City of Portland, Maine - Building or Use Permit Application

Permit No: 2012-50595	Issue Date:	CBL: 344 F024001
---------------------------------	--------------------	----------------------------

Location of Construction: 74 HENNESSY DR	Owner Name: KELLEY PAUL E & MARY A KE	Owner Address: 74 HENNESSY DR	Phone: (207) 797-4983
Business Name:	Contractor Name: William Nutting	Contractor Address: 17 Holmes Rd. Saco	Phone: (207) 283-4019
Lessee/Buyer's Name	Phone:	Permit Type: Additions - Dwellings	Zone: R3
Past Use: Single family	Proposed Use: Same - Single family	Permit Fee:	Cost of Work: \$4,000.00
Proposed Project Description: Building 6' X 10' front porch with stairs - 4' x44"		FIRE DEPT: <input type="checkbox"/> Approved <input type="checkbox"/> Denied <input type="checkbox"/> N/A	INSPECTION: Use Group: Type:
		Signature:	Signature:
PEDESTRIAN ACTIVITIES DISTRICT (P.A.D.)			
Action: <input type="checkbox"/> Approved <input type="checkbox"/> Approved w/Conditions <input type="checkbox"/> Denied			
		Signature:	Date:

Location/Address of Construction: <u>74 Hennessey Dr., Portland</u>		
Total Square Footage of Proposed Structure/Area <u>60</u>	Square Footage of Lot <u>6500</u>	Numb

Plot Plan

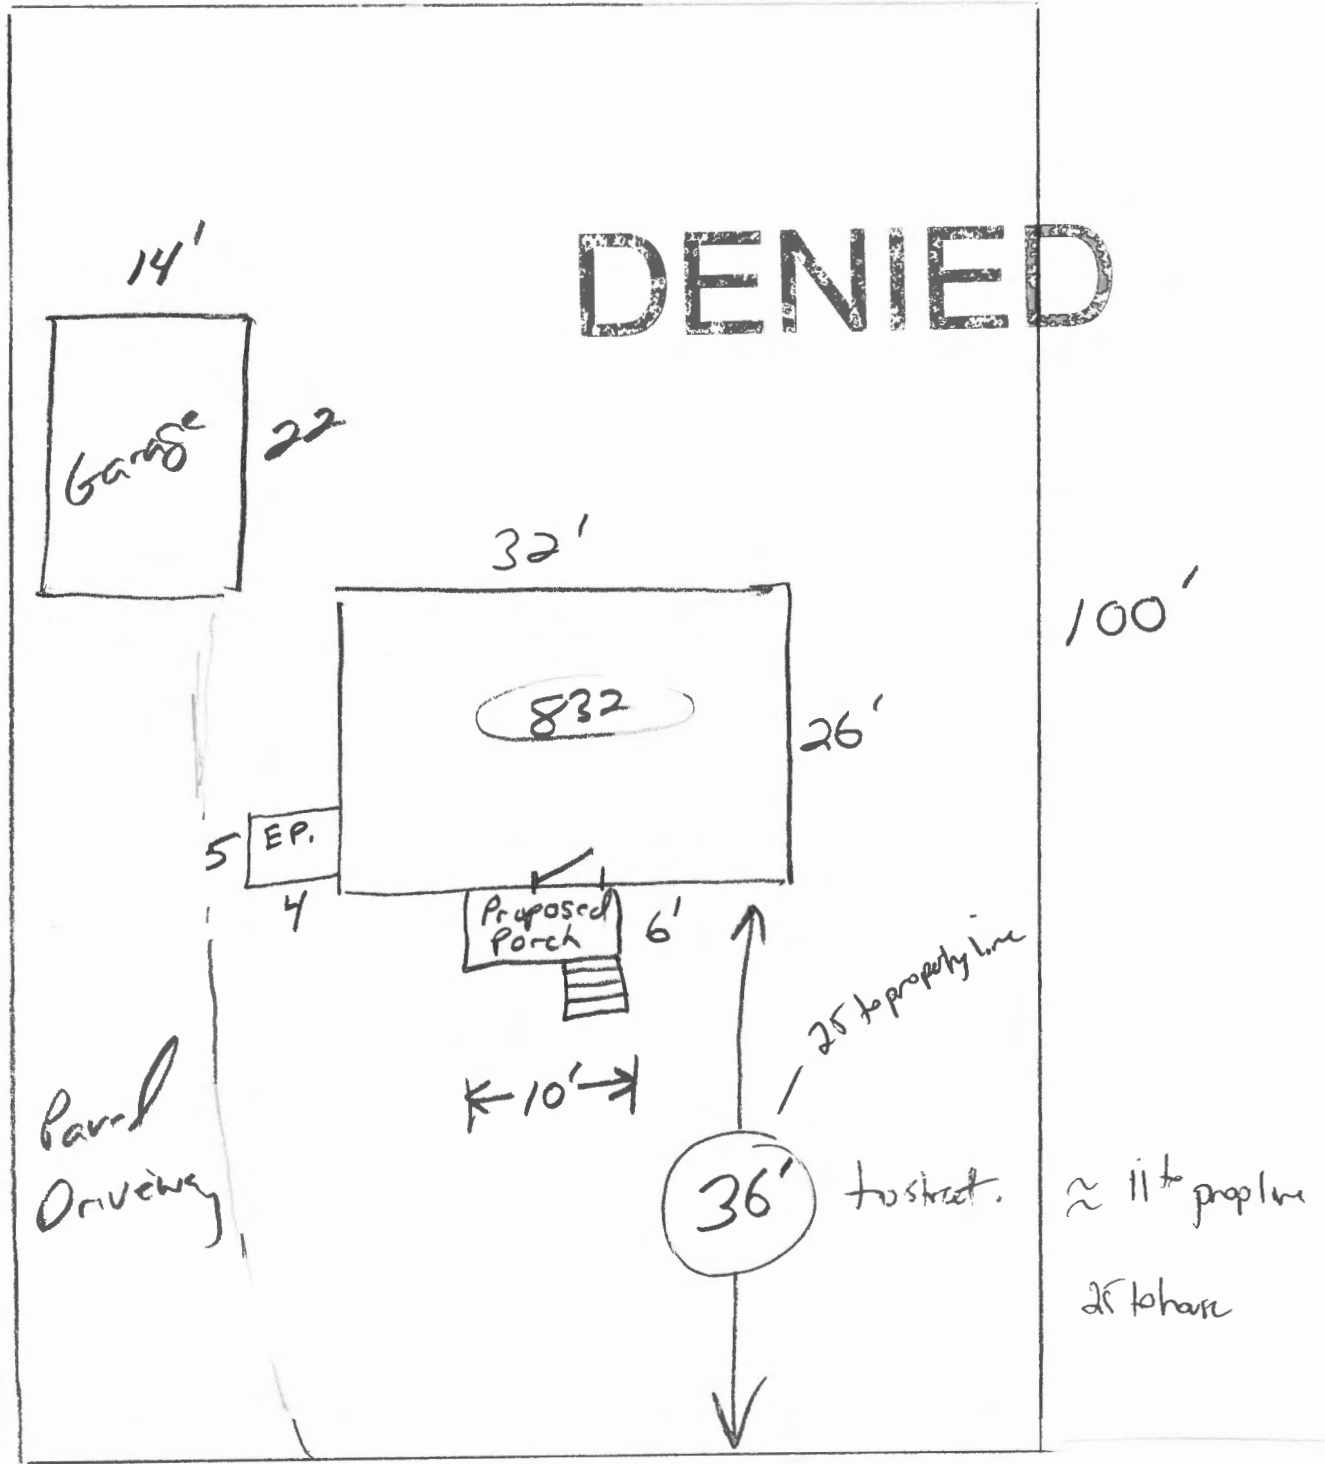
Spoke to contractor, William Nutting. Front setback given on the plot plan is to the street not the front property line. It appears that the proposed porch will not meet the 25' front setback. Permit is on hold until the contractor gets back to me.

Spoke to William Nutting, contractor. He withdrew the application.
